KIRKLEES METROPOLITAN COUNCIL INVESTMENT & REGENERATION SERVICE

DELEGATED DECISION TO DETERMINE PLANNING APPLICATIONS

Reference No:	2023/62/93189/E
Site Address:	51, Kitson Hill Road, Mirfield, WF14 9HA
Description:	Demolition of existing extension and erection of two storey side and single storey rear extensions
Recommending Officer:	Elenya Jackson

OFFICER REPORT: 2023/93189

Drawing Title:
PROPOSED ELEVATIONS

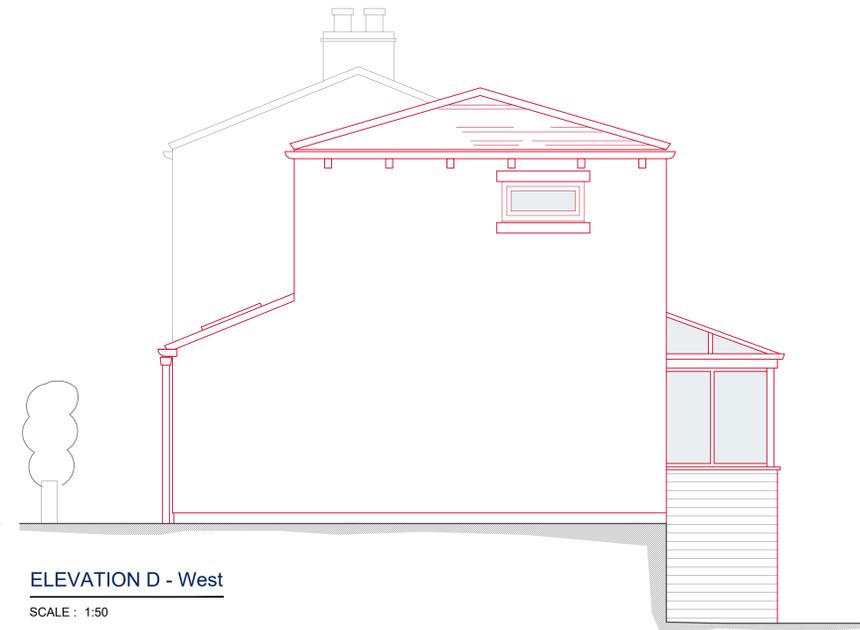
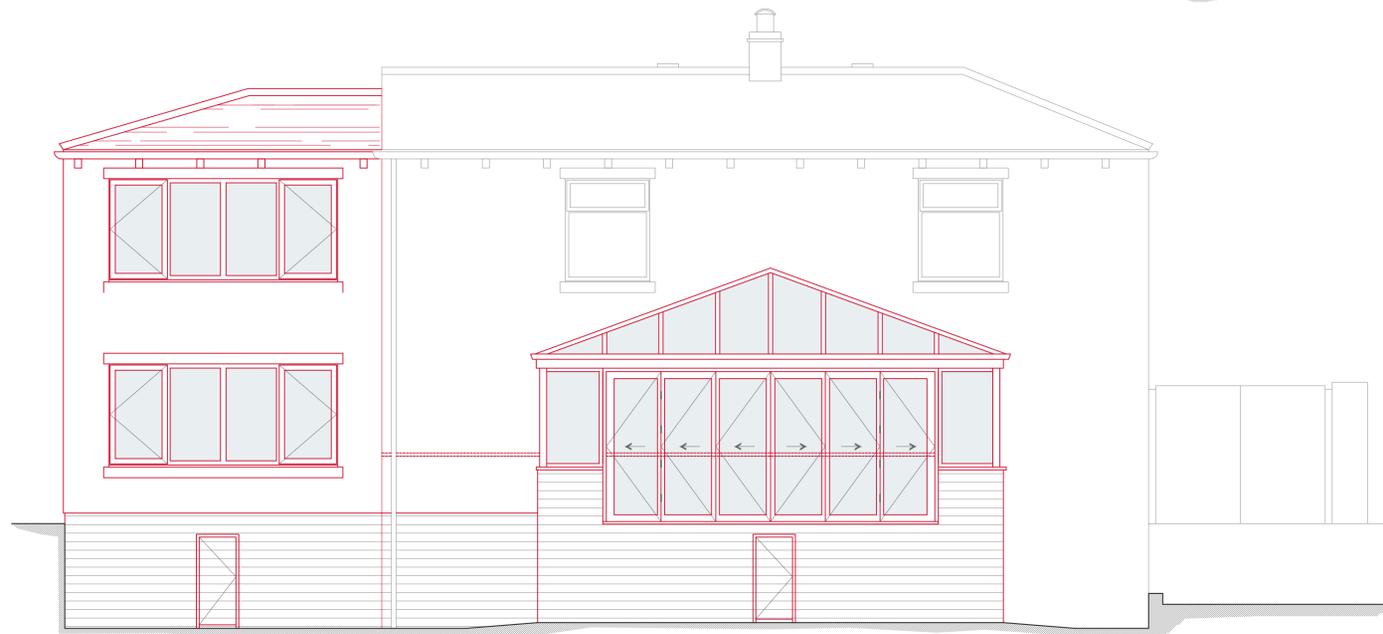
The two storey side extension would extend 4.6m beyond the side elevation of the existing dwelling, have a depth of 7m, a maximum height of 6.2m and be set back from the principal elevation of the dwelling at first floor level by 1.8. The ground floor element of the proposal would be flush with the front elevation of the dwelling.

The single storey rear element of the proposal would extend 3.3m beyond the rear elevation of the dwelling, have a width of 6.7m and a maximum height of 5m; however, due to the change in ground levels between the front and the rear of the site, it would be 3.6m in the context of street level.

In addition, the House Extensions and Alterations SPD sets out that corner plots should be designed with two street frontages with windows overlooking the street, be set back from the building line and follow the boundary treatment along the street. Due to the existing dwelling being set forward within the street scene, the proposed side elevation will appear visually prominent within the street.

Notwithstanding this, the proposal would be set down and back from the host dwelling and would be constructed with materials sympathetic and in-keeping to the host dwelling. The existing dwelling does not feature a rendered finish within its material palette on the original part of the dwelling, although the existing lean-to extension does have a pebble dash render finish. As the plans do not detail where the materials would be located on the proposal it is considered by officers that a condition would be acceptable requiring the principal elevation of the dwelling to be retained in stone to not overly alter the prevailing character of the dwelling.

The single storey rear extension would have a height of more than 4m; however, this is due to the change in ground levels across the site. It is considered that due to the scale and location of the single storey extension and the extent of amenity space associated with the dwelling, it is considered that the single storey extension would accord with the SPD.

3. Notwithstanding the submitted details, the front elevation of the side extension hereby approved shall be constructed of stone sympathetic in colour and texture to the appearance of the existing building, and the side and rear elevations shall be faced in render. The roofing material shall match that used in the construction of the existing building.

Drawing Title:
PROPOSED FLOOR PLANS

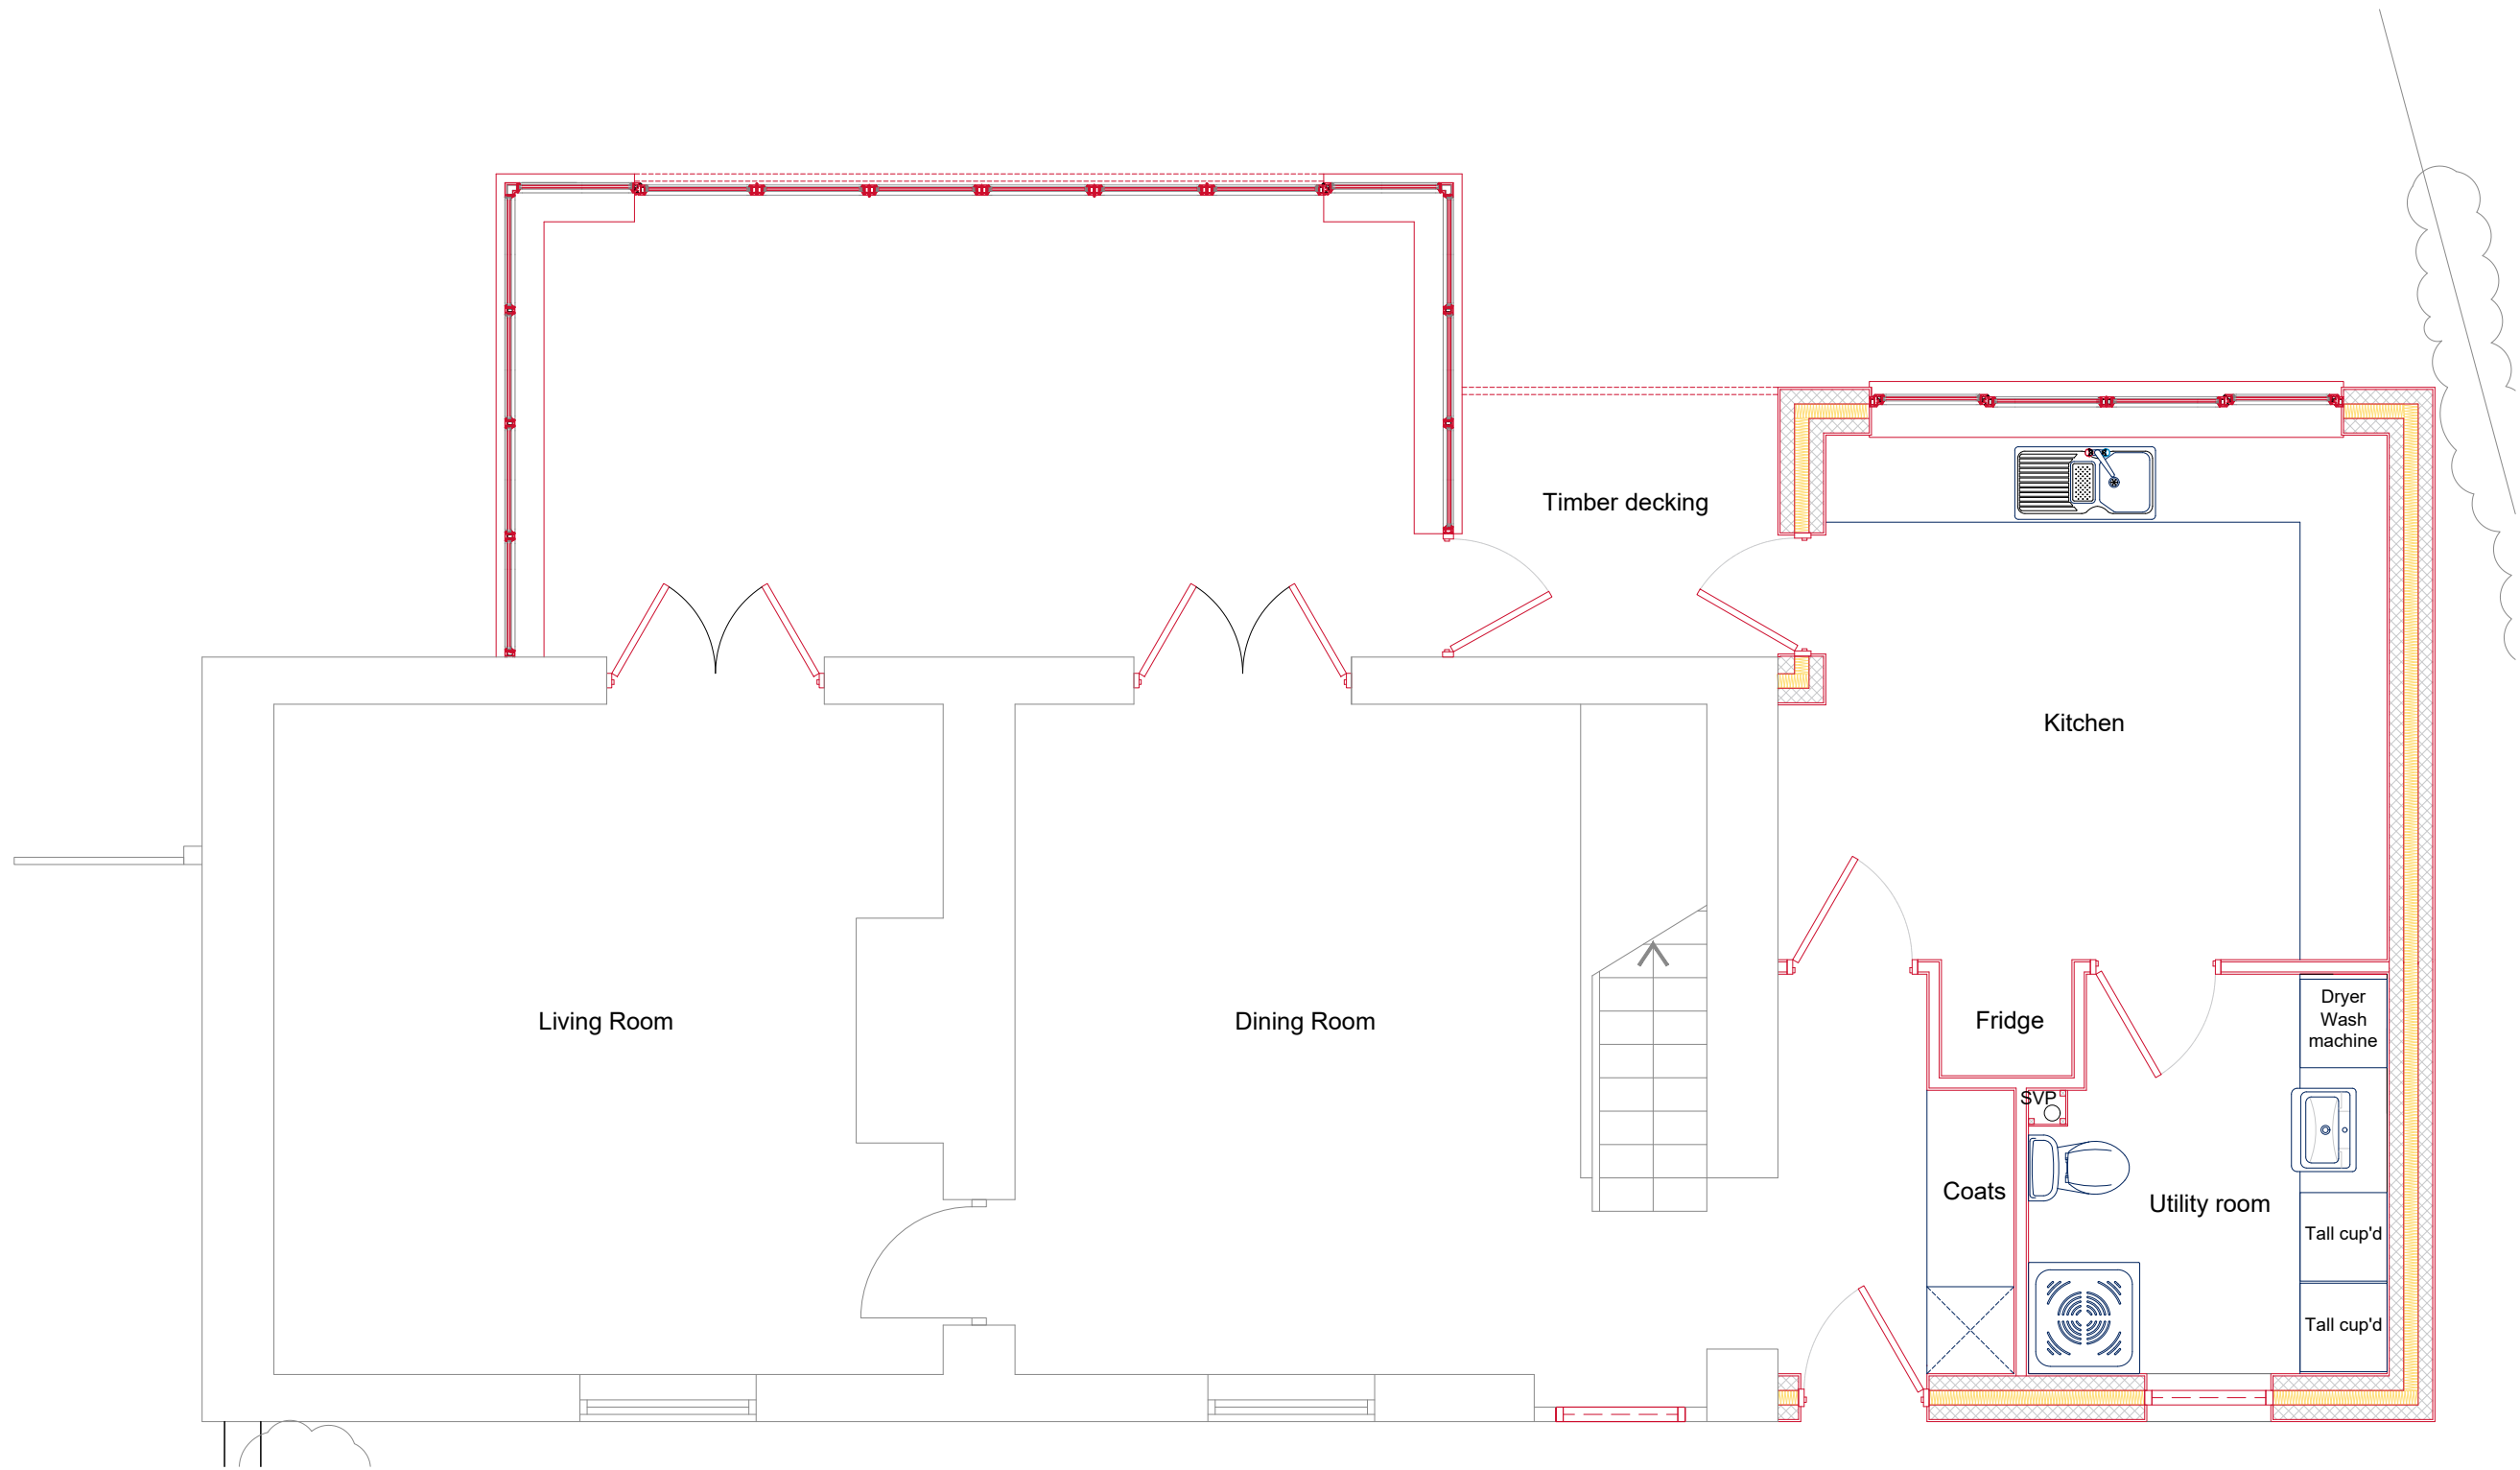
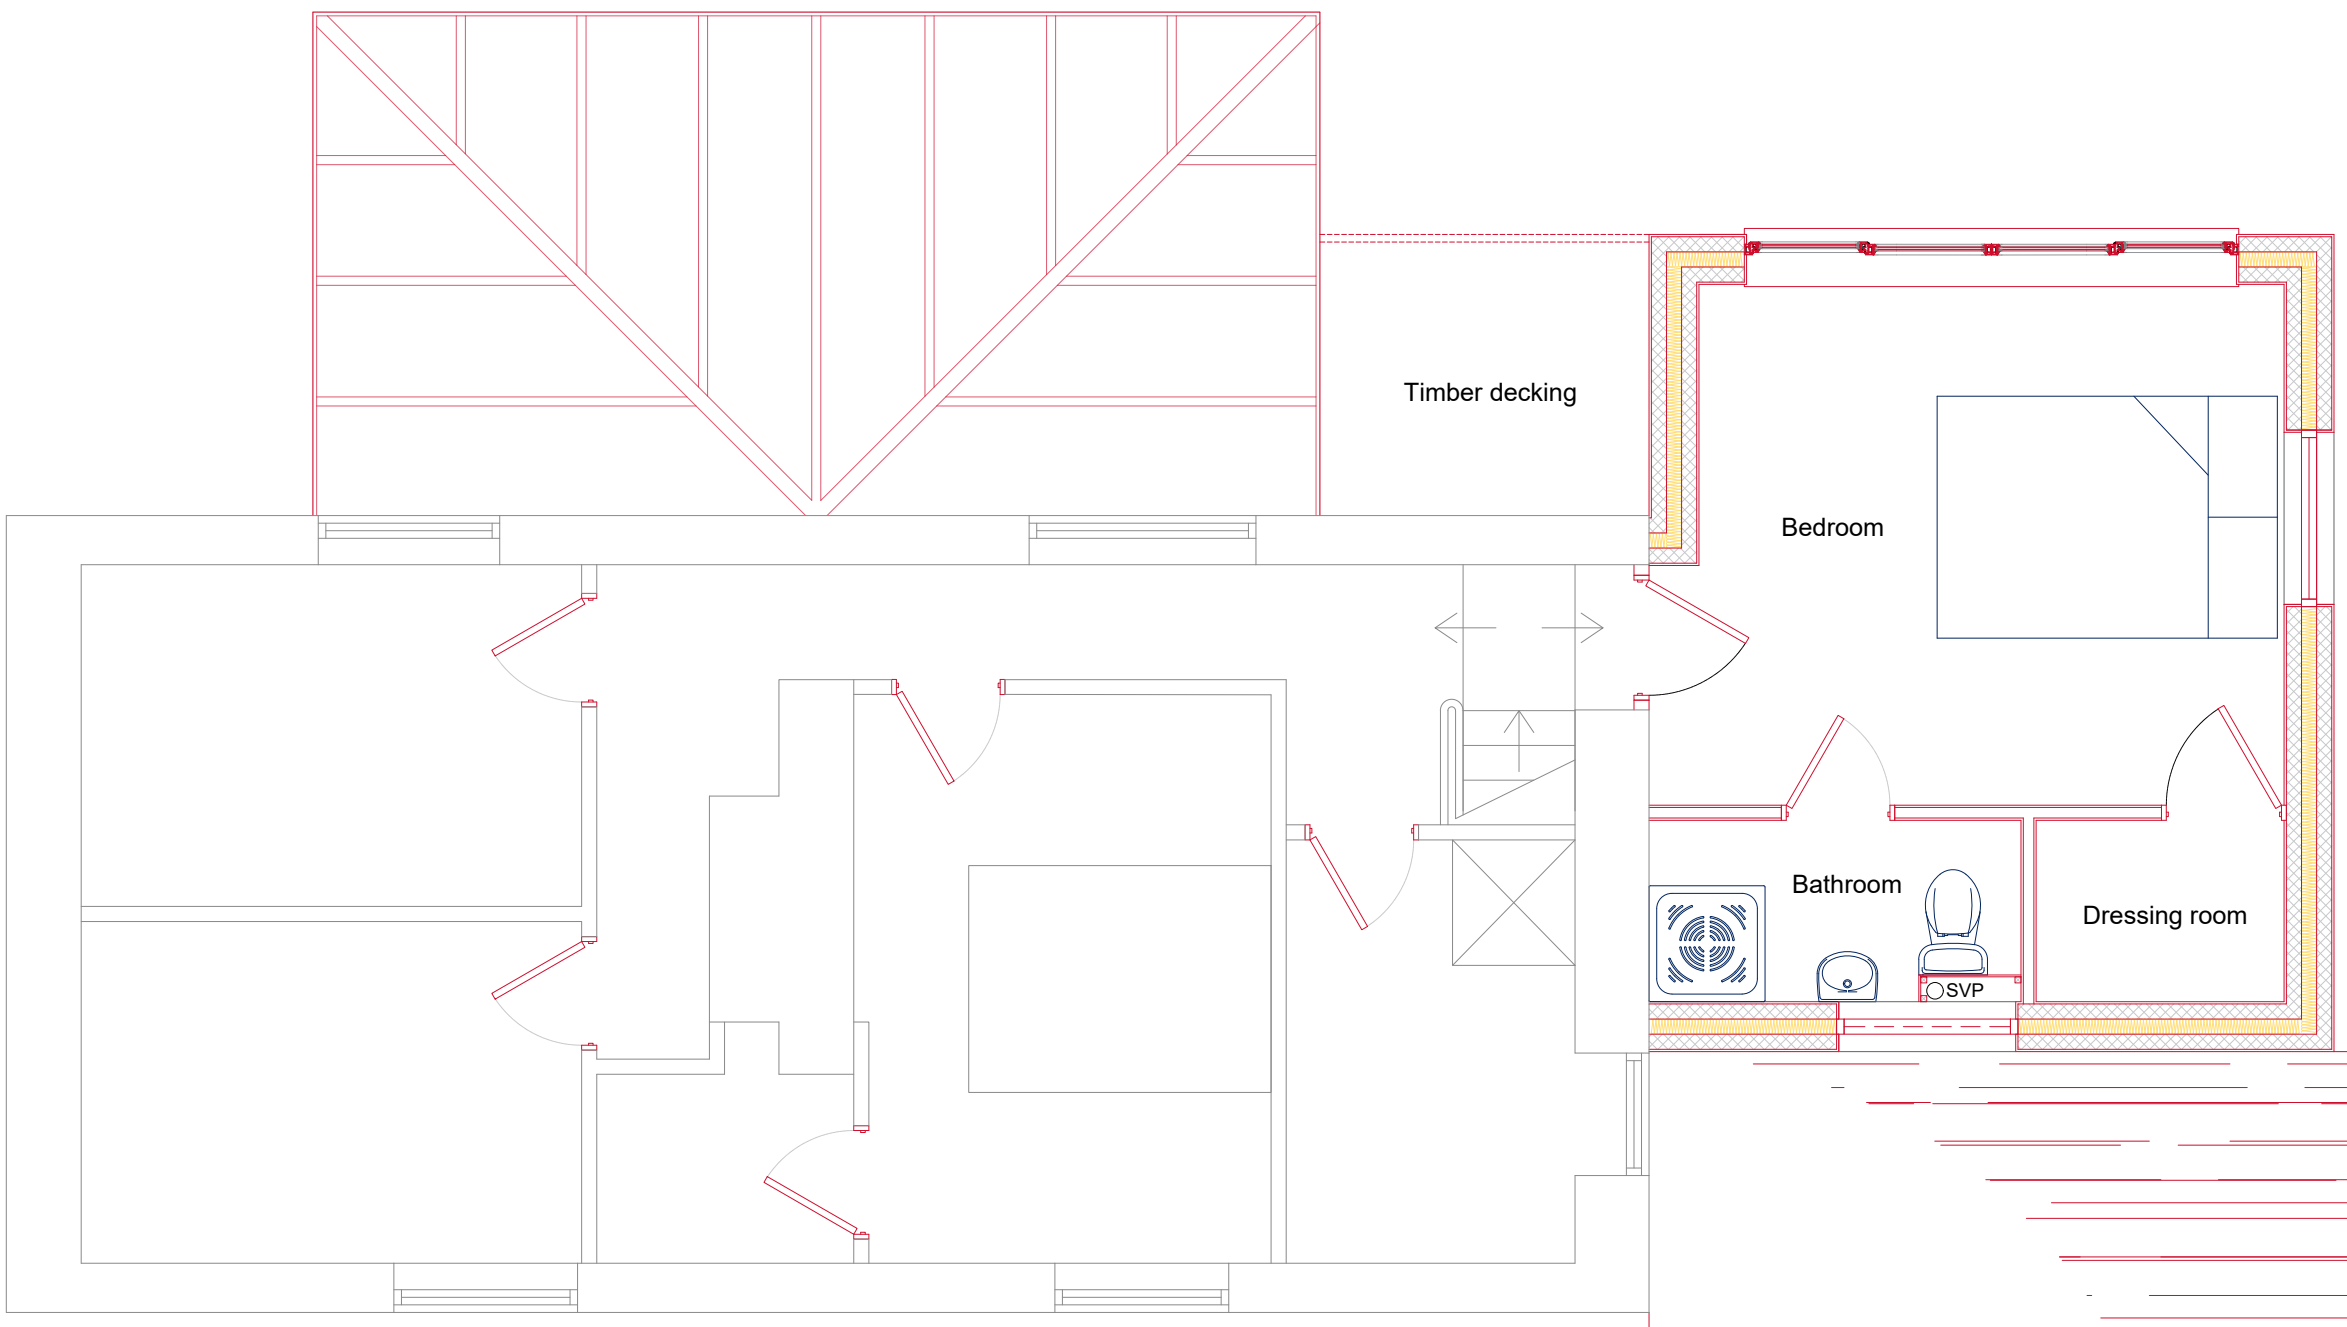
Impact on 53 Kitson Hill Road: adjoins the application property to the west. Overlooking: The proposed rear extension would feature side facing windows. No.53 features two first floor side facing windows which feature obscured glazing. The side facing windows in the orangery would be set a reasonable distance from the shared boundary and not be the only vantage point from the orangery. In relation to the side extension, this would be set forward and at an angle to No.53 such that no loss of privacy would result to the occupants of No.53.

The proposals would result in the intensification of the domestic use of the site due to it creating four bedrooms. The site currently has a driveway and the plans indicate 3 parking spaces would be retained. The proposal would not result in the loss of any parking spaces on site and the site does have additional space should further parking be required., it is considered that due to no spaces being lost as a result of the proposal, the proposal is considered to comply with Policy LP22 of the Kirklees Local Plan along with Key Design Principles 15 & 16 of the House Extensions & Alterations SPD.
